A428 Black Cat to Caxton Gibbet improvements

9.88 Schedule of Changes to the Environmental Masterplan

Regulation Reference:	Rule 8(1)(k)
Planning Inspectorate Scheme Reference	TR010044
Application Document Reference	TR010044/EXAM/9.88
Author	A428 Black Cat to Caxton Gibbet Improvements Project Team, National Highways

Version	Date	Status of Version
Rev 1	14 December 2021	Final for Deadline 6
Rev 2	25 January 2022	Final for Deadline 9

Drawing Number: HE551495 - ACM - ELS - GEN_SW_Z_ZZ_DR-LV-0010
 Location: I Type: 1 Role: 1 Number: P04

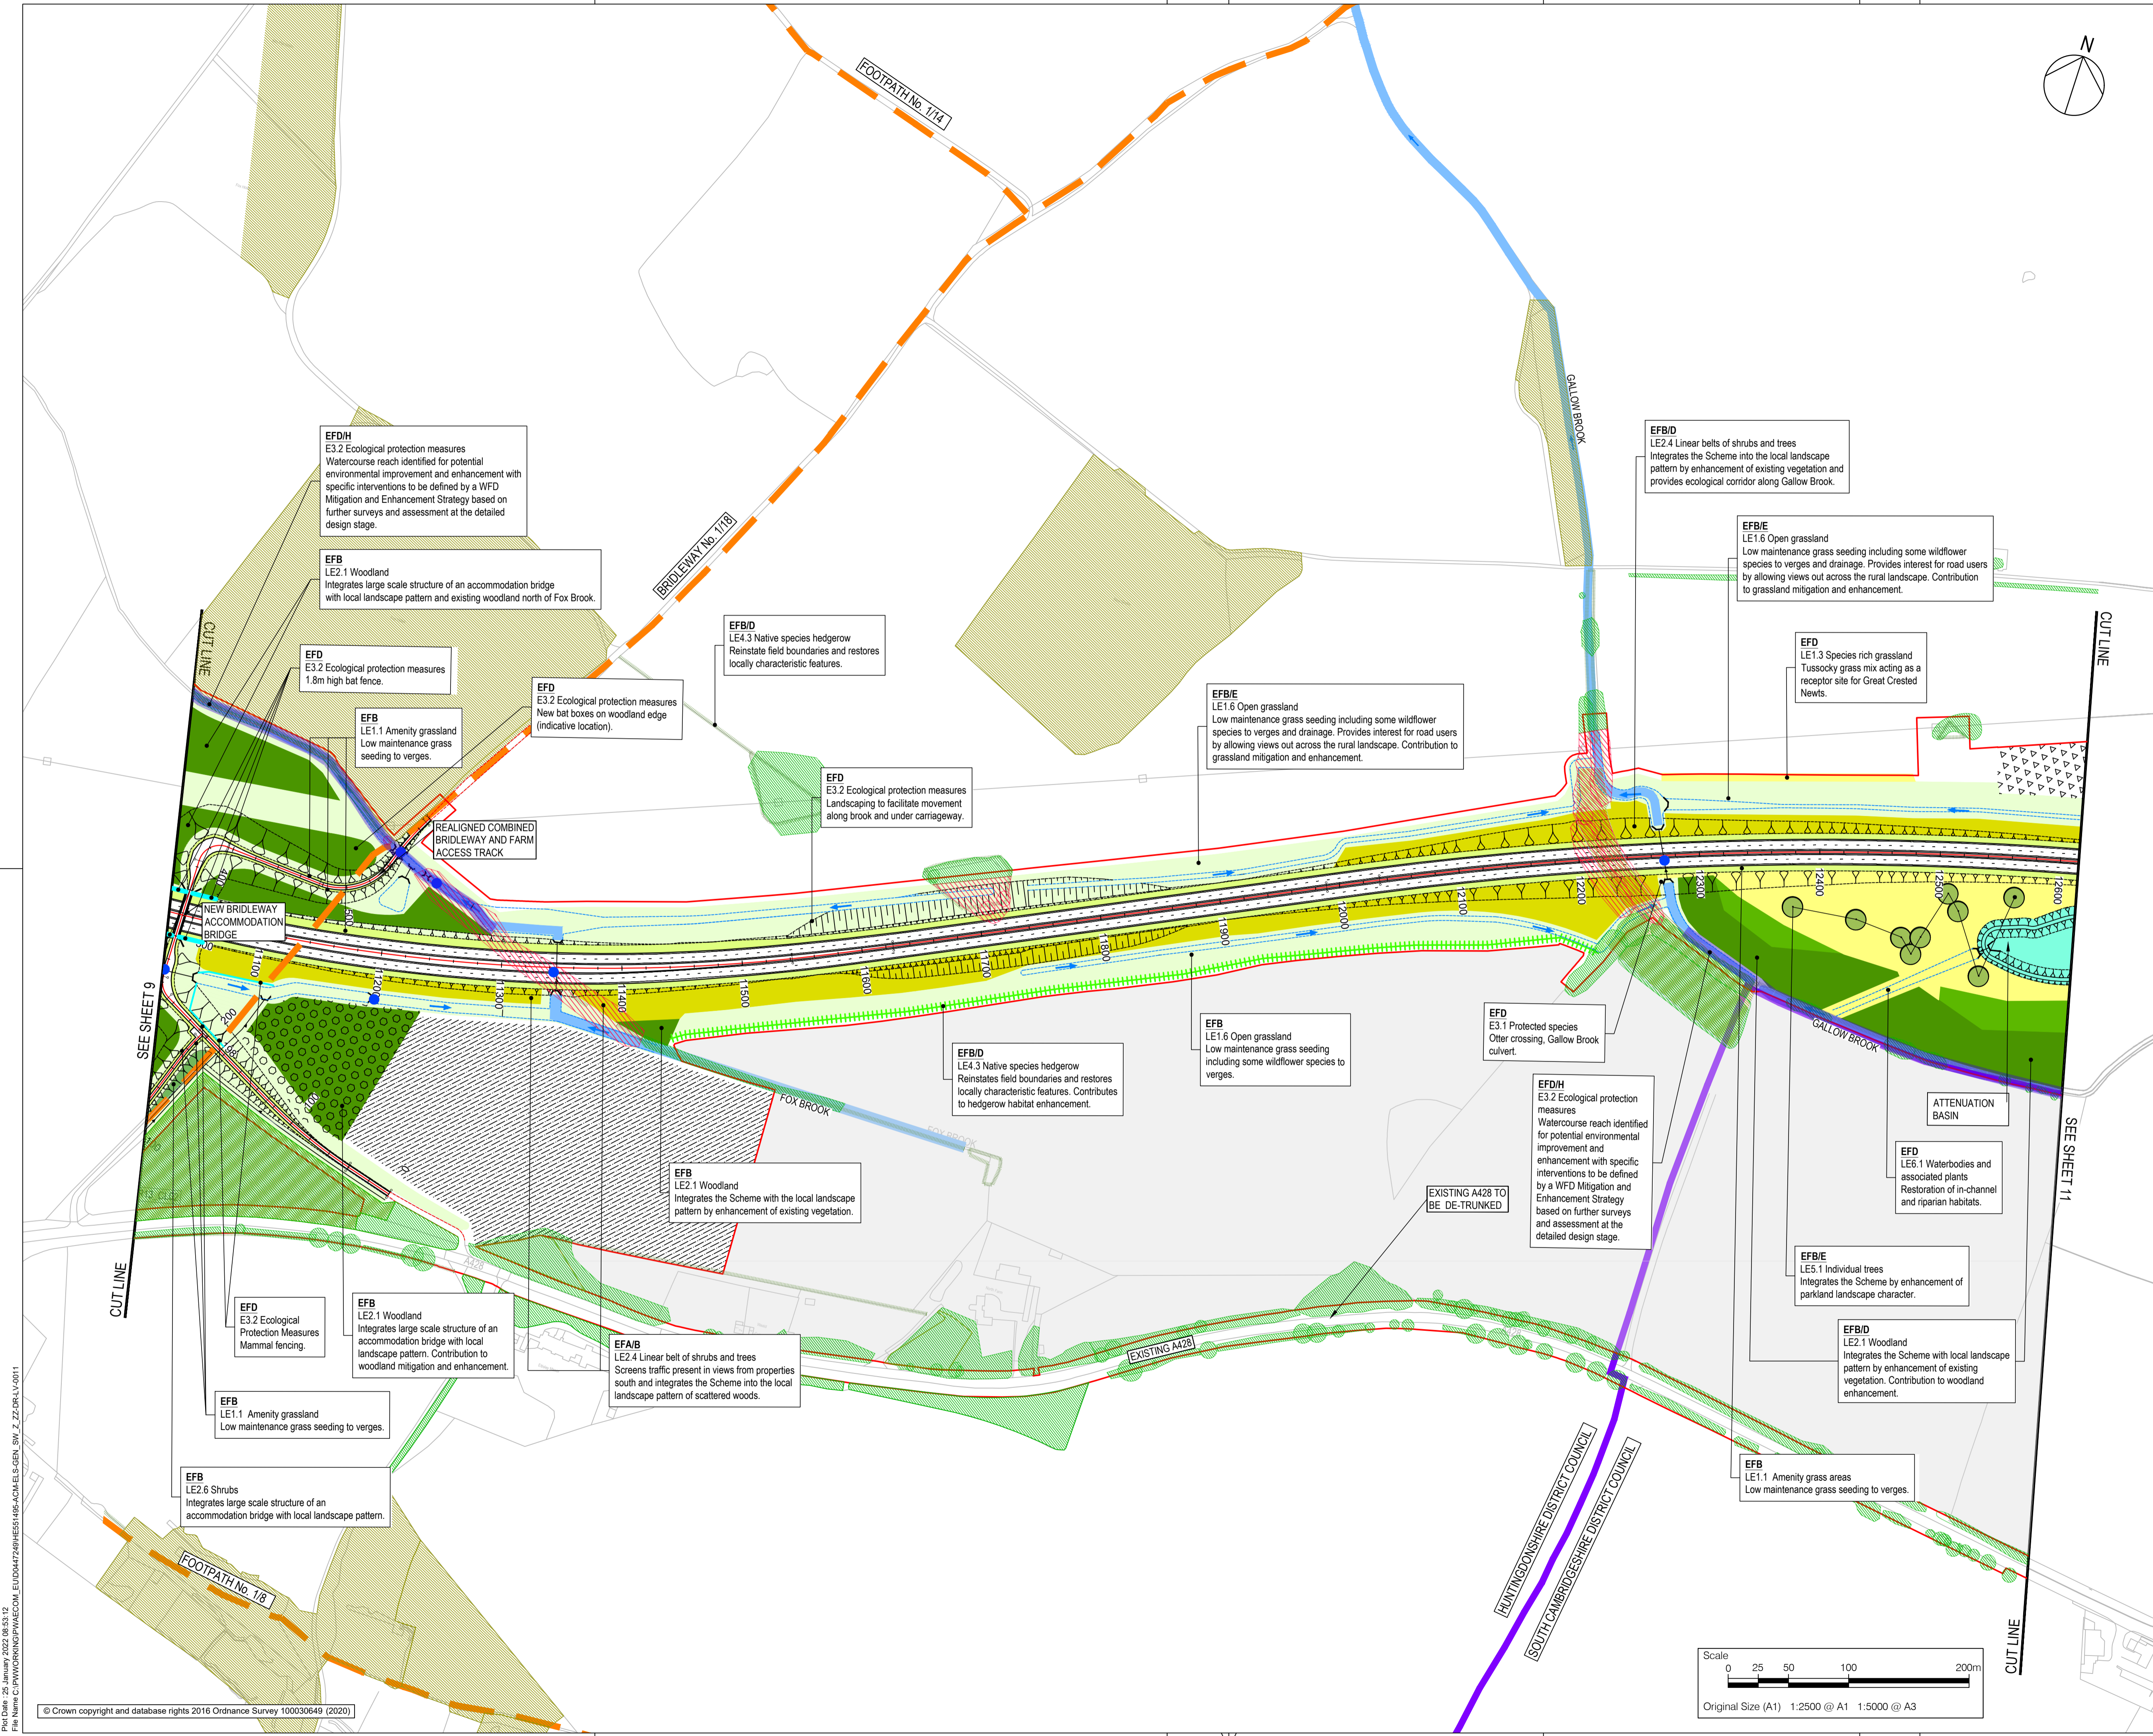
19	DR-LV-0010 between chainage 0 - 50	Natural England	Add short section of hedge to fill gap up to road to ensure habitat connectivity.	Hedge added	Deadline 9	Figure 2.4v4
20	DR-LV-0009 at chainage 8690	National Highways	Review of the masterplan noted that some of the fencing structures were not visible or not considered of the correct type to act as bat mitigation.	Further labelling of figure to highlight where fencing has been included to deter bats from crossing the proposed carriageway and encourage bats (along with planting) to use the proposed pedestrian bridge crossing.	Deadline 9	Figure 2.4v4
21	DR-LV-0011 at chainage 11050	National Highways	Review of the masterplan noted that some of the fencing structures were not visible or not considered of the correct type to act as bat mitigation.	Further labelling of figure to highlight where fencing has been included to deter bats from crossing the proposed carriageway and encourage bats (along with planting) to use the proposed bridleway accommodation bridge.	Deadline 9	Figure 2.4v4

Drawing Number: HE551495 - ACM - ELS - GEN_SW_Z_ZZ - DR - LV - 0012
 Location: I Type: 1 Role: 1 Number: P05

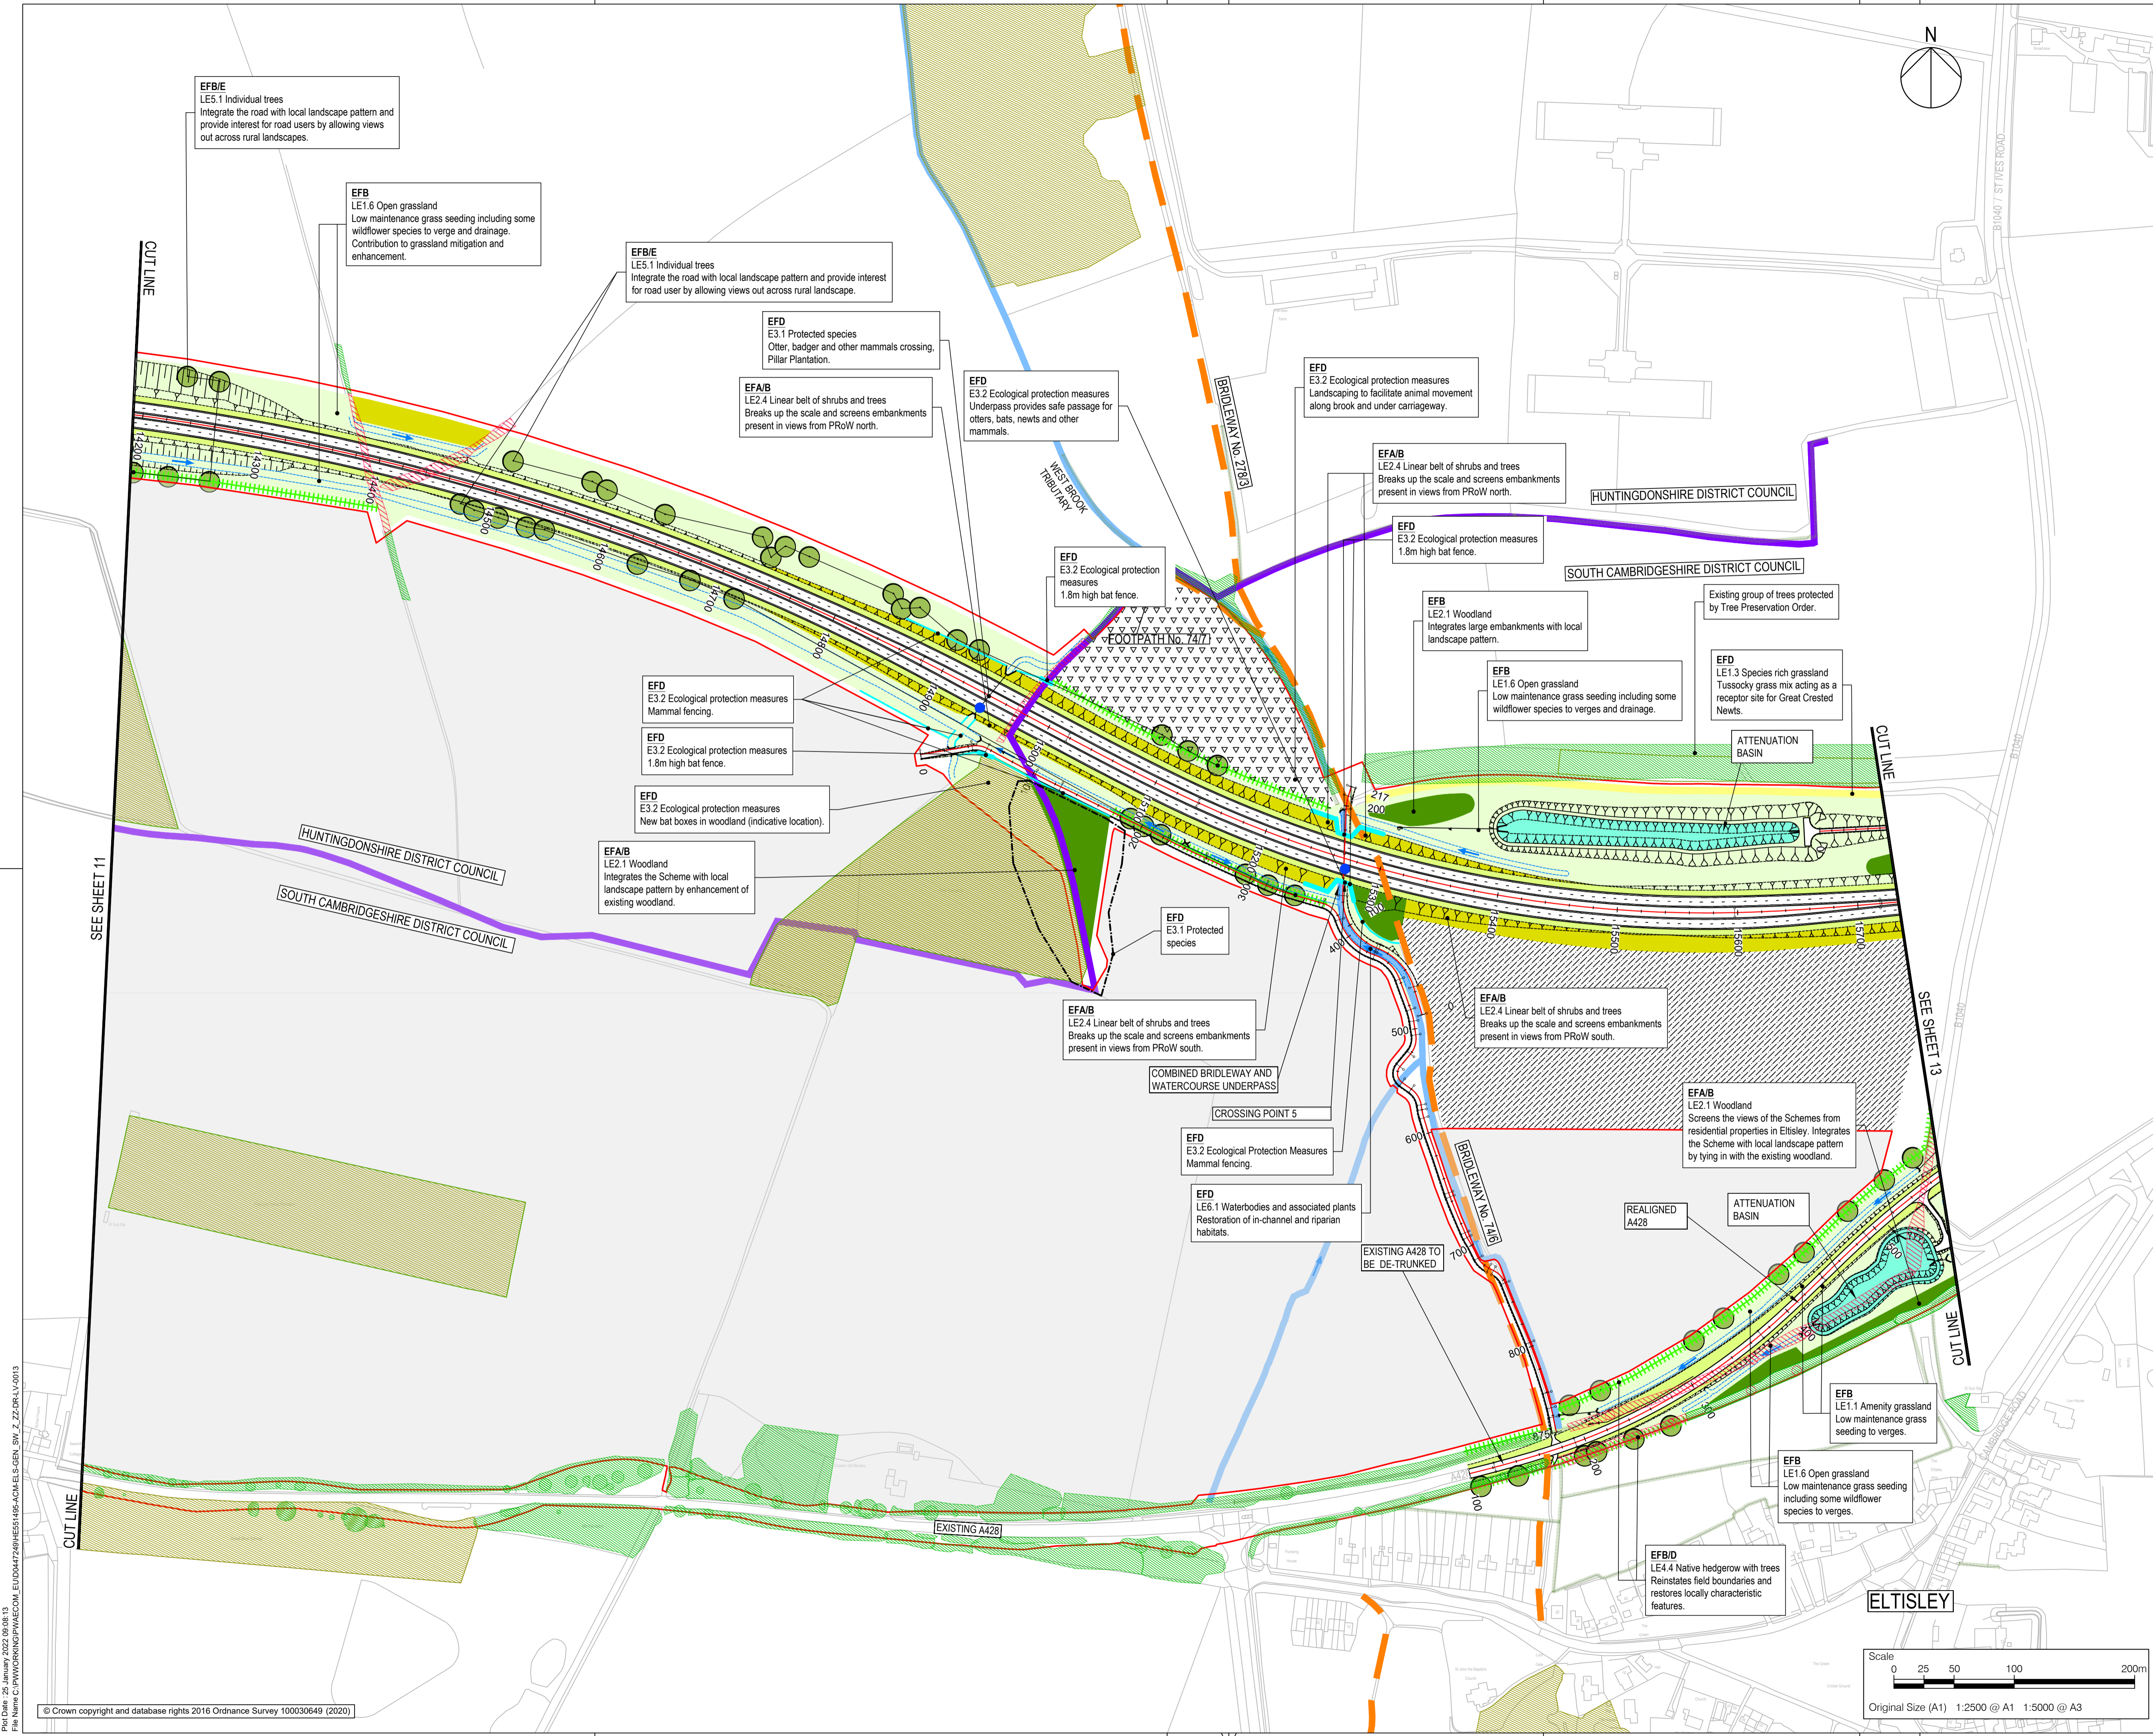
Ref.	Environmental Masterplan page no Ref. with chainage	Consultee	Comments from consultee (Rationale for the change)	Change made	Deadline submitted	Environmental Masterplan Version
12	DR-LV-0012 between chainage 12800 – 12900	Natural England	GCN Mitigation Licence	LE1.3 Species rich grassland Tussocky grass mix as terrestrial habitat Great Crested Newts.	Deadline 6	Figure 2.4v3
13	DR-LV-0013 between chainage 15600 - 15700	Natural England	GCN Mitigation Licence	LE1.3 Species rich grassland Tussocky grass mix as terrestrial habitat for Great Crested Newts added.	Deadline 6	Figure 2.4v3
14	DR-LV-0015 between chainage 18200 – 18300	Natural England	GCN Mitigation Licence	LE6.1 Waterbodies and associated plants, pond proposed as receptor site for GCN.	Deadline 6	Figure 2.4v3
15	DR-LV-0005 between chainage 4650 - 4800	Natural England/ Bedford Borough Council	Further planting required to guide bats into the bat tunnel.	Minor amendment to woodland planting proposed adjacent to the bat tunnel entrances. Clarification on fencing to help guide bats into the tunnel.	Deadline 9	Figure 2.4v4

Ref.	Environmental Masterplan page no Ref. with chainage	Consultee	Comments from consultee (Rationale for the change)	Change made	Deadline submitted	Environmental Masterplan Version
22	DR-LV-0012 between chainage 12900 - 12990	National Highways	Review of the masterplan noted that some of the fencing structures were not visible or not considered of the correct type to act as bat mitigation.	Further labelling of figure to highlight where fencing has been included at Toseland Road Bridge that allows access east to west movement of bats and screens adjacent habitats from the road.	Deadline 9	Figure 2.4v4
23	DR-LV-0012 between chainage 13290 - 13310	National Highways	Review of the masterplan noted that some of the fencing structures were not visible or not considered of the correct type to act as bat mitigation.	Further labelling of figure to highlight where fencing has been included to encourage commuting/foraging bat to use other adjacent habitats and not across the proposed carriageway.	Deadline 9	Figure 2.4v4

24	DR-LV-0012 between chainage 14050 - 14060	National Highways	Review of the masterplan noted that some of the fencing structures were not visible or not considered of the correct type to act as bat mitigation.	Further labelling of figure to highlight where fencing has been included to encourage commuting/foraging bats to use other adjacent habitats and not across the proposed carriageway.	Deadline 9	Figure 2.4v4
25	DR-LV-0013 between chainage 14980 - 14990	National Highways	Review of the masterplan noted that some of the fencing structures were not visible or not considered of the correct type to act as bat mitigation.	Further labelling of figure to highlight where fencing has been included to encourage commuting/foraging bats to use other adjacent habitats including towards the underpass and not across the proposed carriageway.	Deadline 9	Figure 2.4v4
